Case Officer: Emma Whitley

Applicant: Planned Approach Architects

Proposal: Variation of Condition 2 of 20/02859/F - to change the roof pitch from 12 to 15 degrees

As Proposed

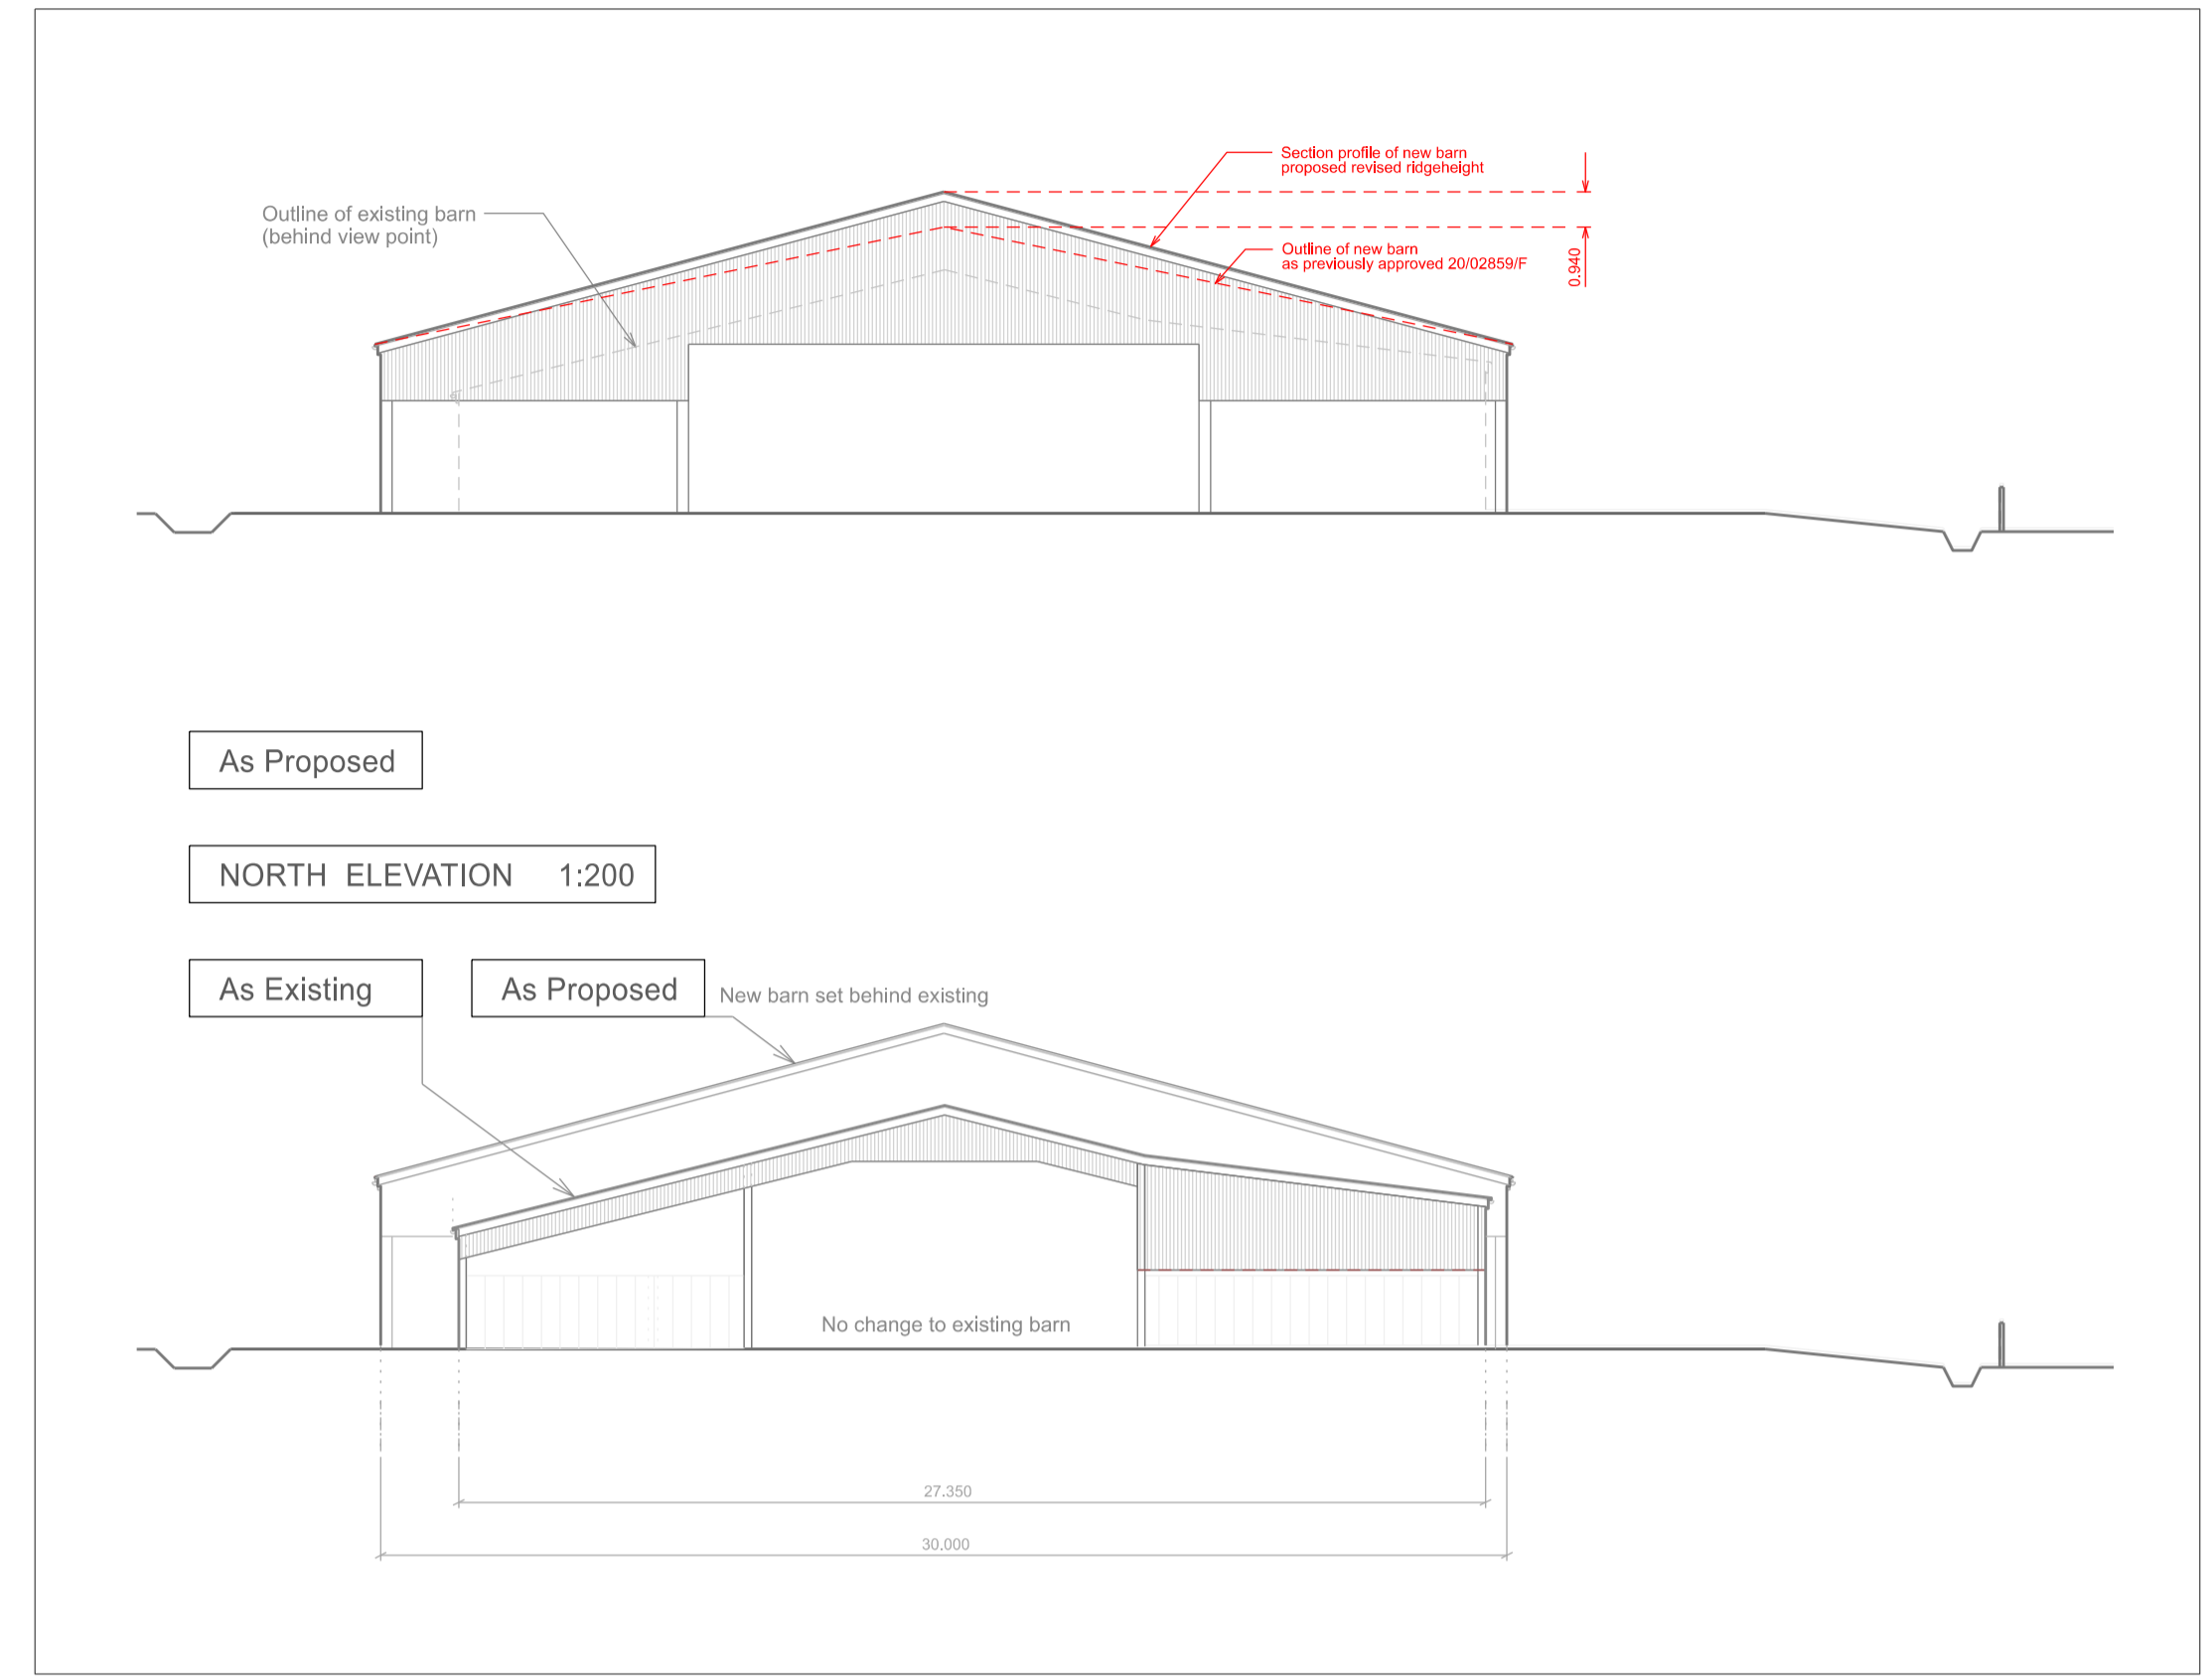
- 2.1. Planning permission is sought to vary condition 2 of permission 20/02859/F to alter the roof pitch of the building from 12 to 15 degrees, resulting in an increased roof height from 8.05m to 8.99m.
- 2.2. The change in pitch is required to make more efficient use of steel in the construction of the barn and in order to accommodate contractor's machinery to tip trailers inside the building.

- 8.7. The amendment to the roof pitch is not considered to result in any additional harm to the visual amenities than previously assessed.
- 8.8. Given the assessment above, it is concluded that the proposal accords with the above Policies in respect of its visual impact.
